Submission re 37 Archer St SSD- 73277714

My submission is around traffic and active transport matters, and I refer to the proponent's Transport and Parking Impact Assessment (TPIA) (May 1995).

The proposal is for a mixed use building accommodating a food and beverage retail outlet, commercial property, and 125 apartments.

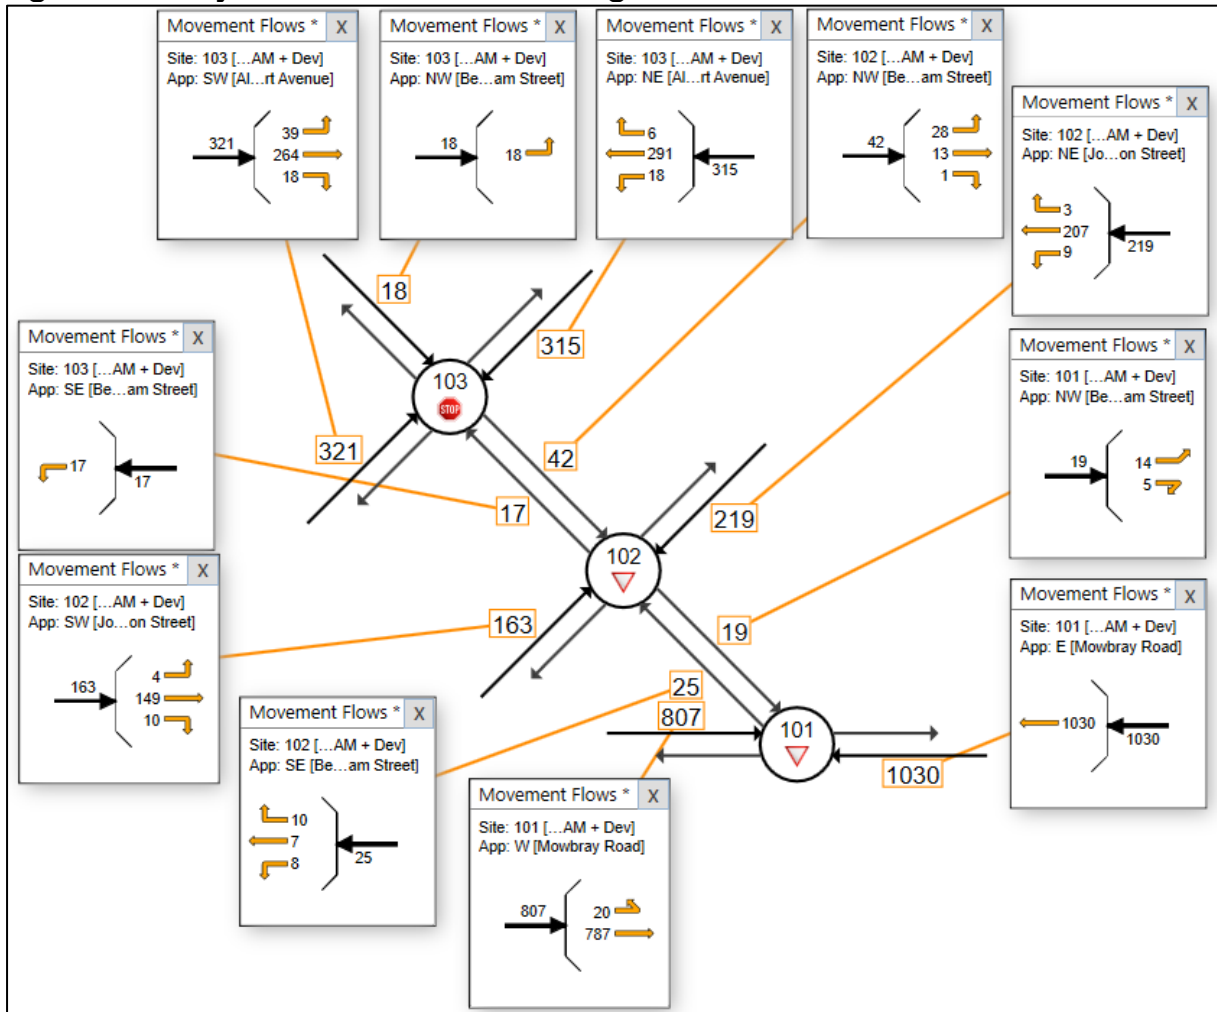
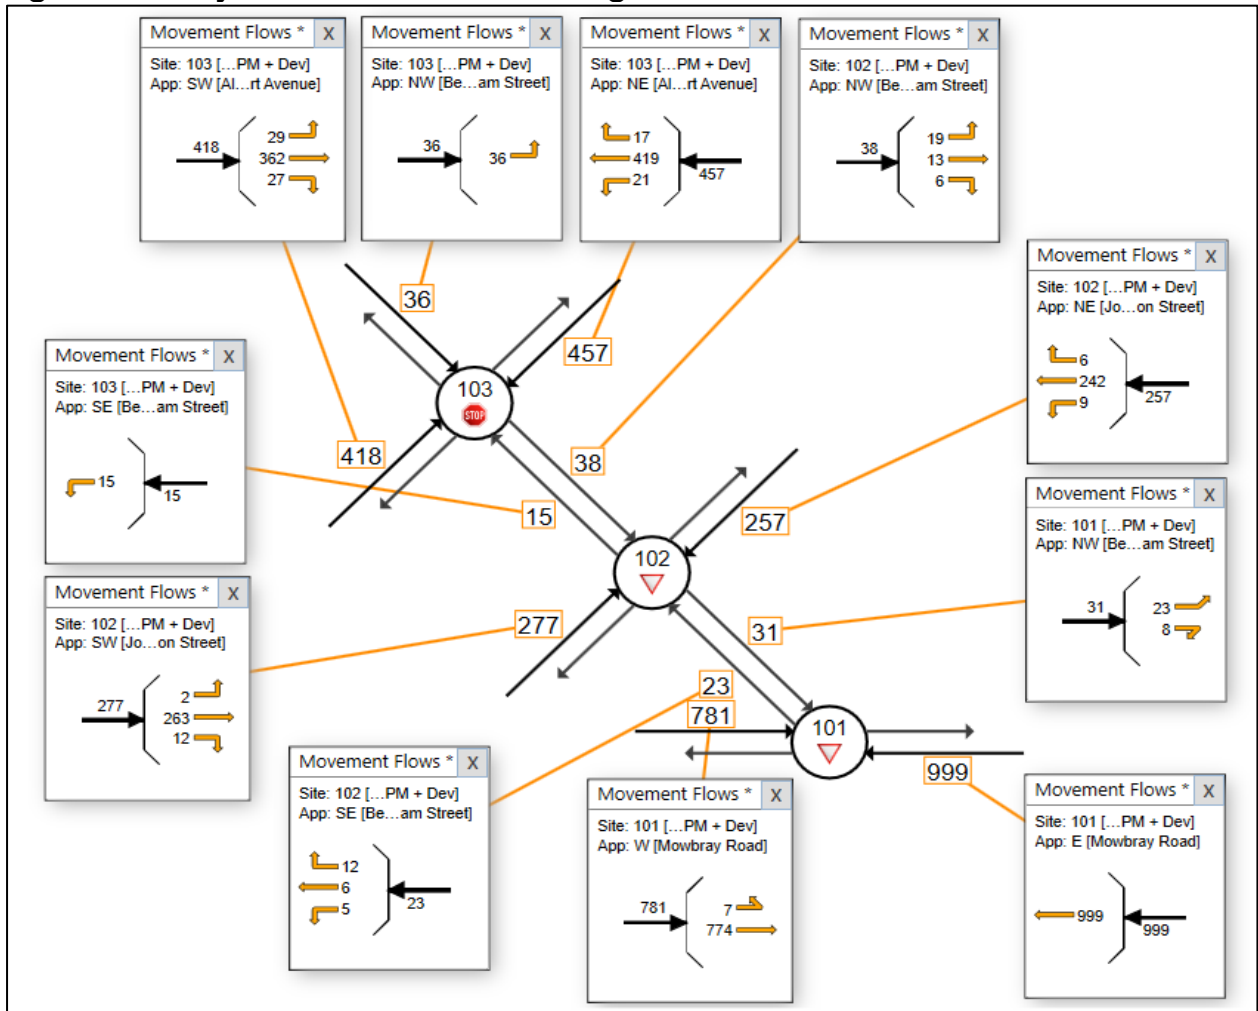
Local vehicle access would be by Bertram St to/from Albert Ave or Johnson St or Mowbray Rd. The proponents TPIA asserts that the Albert Ave/Bertram St intersection operates at LOS A at AM and PM peak times.

Personal observation and data from other sources suggest the proponent's TPIA takes a very simplistic view of traffic and is significantly flawed. The TPIA considers only the Bertram St intersections with Albert Ave, Johnson St, and Mowbray Rd, and finds that the intersections all operate at mainly LOS A, with occasional LOS B. This is a totally illusional view of local traffic conditions

I refer first to assessment of local intersections, specifically on Albert Ave, and the Transport Impact Assessment (TIA) (27/9/2024) lodged as an EIS document by the nearby 57-61 Archer St and 34 Albert Ave development proponent. That proponent lodged a significantly more detailed and, in my opinion, realistic TIA noting

- Light controlled intersection at Albert Ave/Neridah St intersection (adjacent to the Bertram St/Albert Ave intersection), **not acknowledged in the 37 Archer St proponent's TPIA**
- Tendency for traffic to back up in Albert Ave between Archer St and Neridah St traffic lights, potentially blocking the entry to/exit from Bertram St. This tendency will increase in future years.**
- Existing and growing congestion at the Albert Ave/Archer St lights

The proponent's traffic observations were on week days, 7-9 AM and 4-6 PM. Chatswood is a retail centre with dominantly retail traffic, and many of the major retailers do not open until after 9 AM. Chatswood Chase advertises its weekday opening hours as 9:30 AM to 5:30 AM. Chatswood Chase vehicle entry data confirms the peak time for retail vehicle traffic is 10 AM to 12 AM (figure below). Albert Ave is only lightly used in the hours 7-9 AM. The proponent's traffic study thus does not capture a period of very significant local traffic. The Chatswood Chase traffic data also shows very significant traffic on Saturdays. Weekend traffic was not included in the proponent's traffic study.

It is apparent that the TPIA does not correctly represent the traffic conditions, present or future, in the vicinity of the proposed development site. Better accuracy is required, and more bike spaces, consistent with a desire to encourage Green Travel.
